Grandview Reserve On Site Sanitary Sewer

El Paso County No. PPR2421

Grandview - SWMP Checklist - Submittal 1 Comment Response

CIVIL
SITE GRADING PLAN

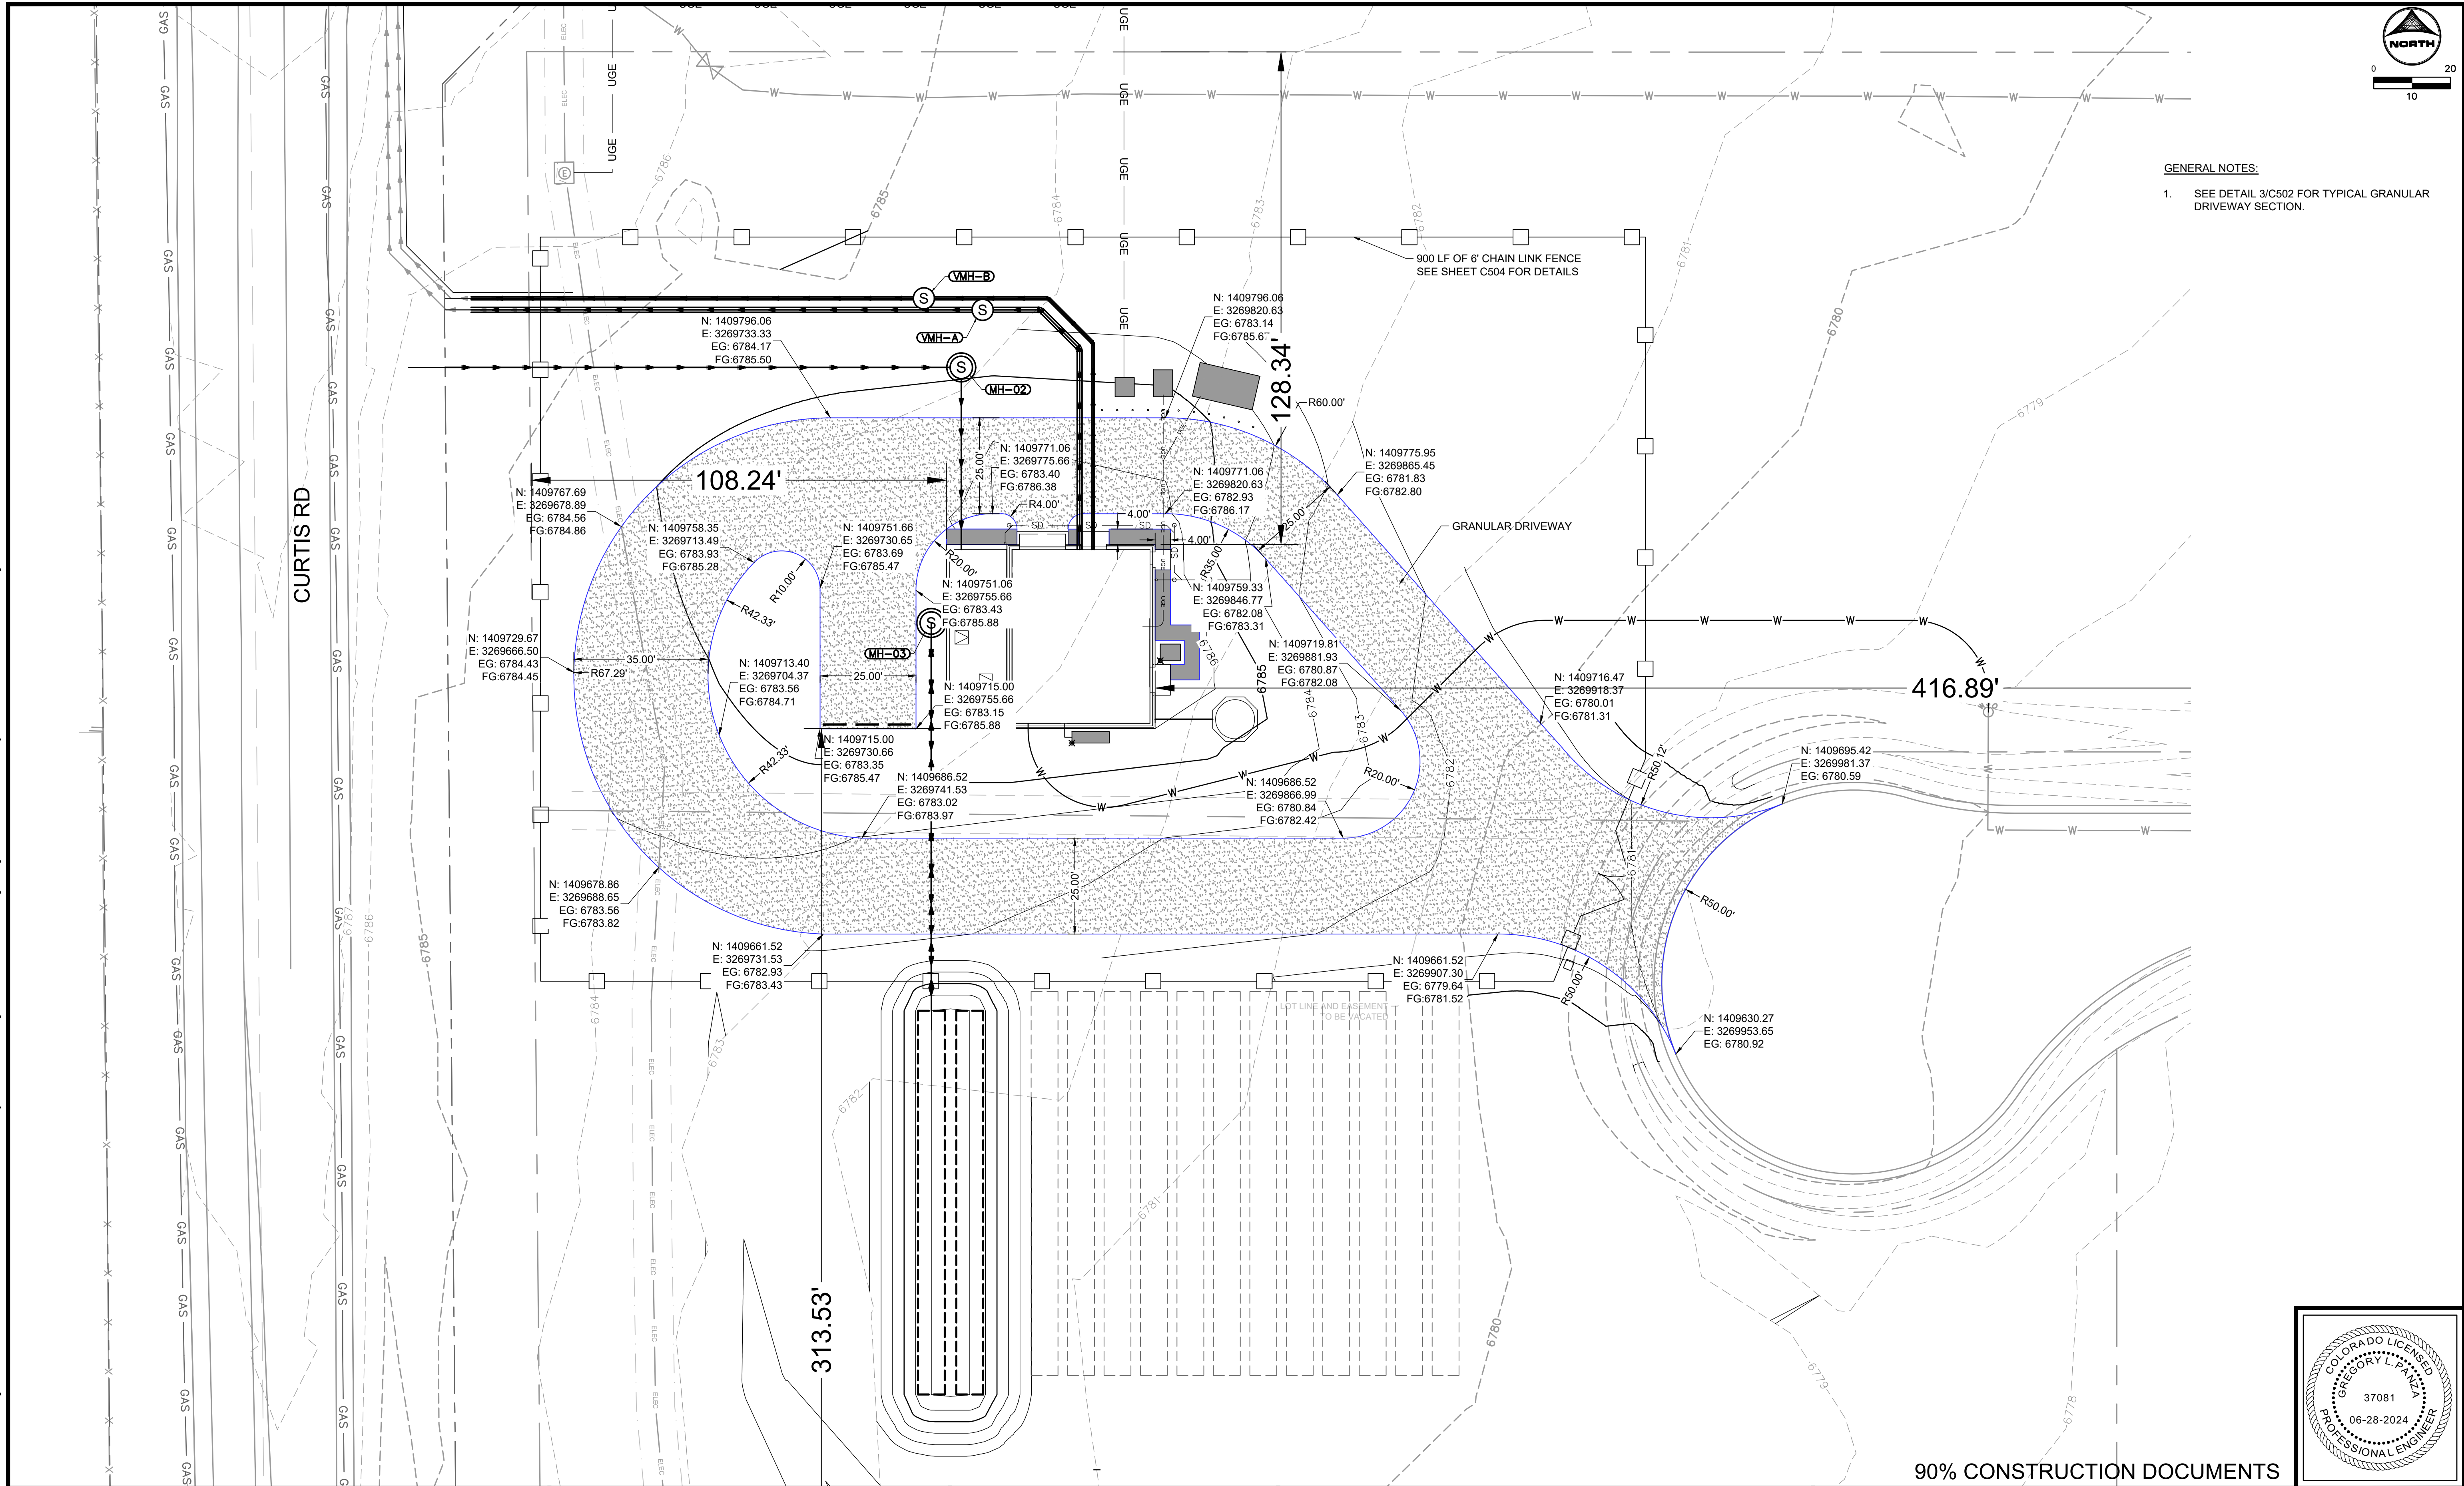
Page Label	Comments	Author	Date	HR Green Response
1	4 checklist were included for the 4 projects. Please label which checklist is for which project.	Glenn Reese	7/29/2024	Title of each SWMP checklist added. Dividers also added.
1	Discuss these in the SWMP	Glenn Reese	7/29/2024	Added
1	PPR2421	Glenn Reese	7/29/2024	Added
1	The comments provided on this checklist apply to all 4 project SWMPs	Glenn Reese	7/29/2024	Acknowledged
2	N	Glenn Reese	7/29/2024	Permanent stormwater features will be mitigated by the Saddlehorn development. Statement added to lift station SWMP.
2	Long-term Stormwater Quality	Glenn Reese	7/29/2024	
2	structural measures	Glenn Reese	7/29/2024	
2	detention, water quality control measure	Glenn Reese	7/29/2024	
2	N	Glenn Reese	7/29/2024	Updated legend to state "limits of construction/disturbance"
2	N	Glenn Reese	7/29/2024	Grading sheet with cut/fill area added to GEC plans (Appendix B)
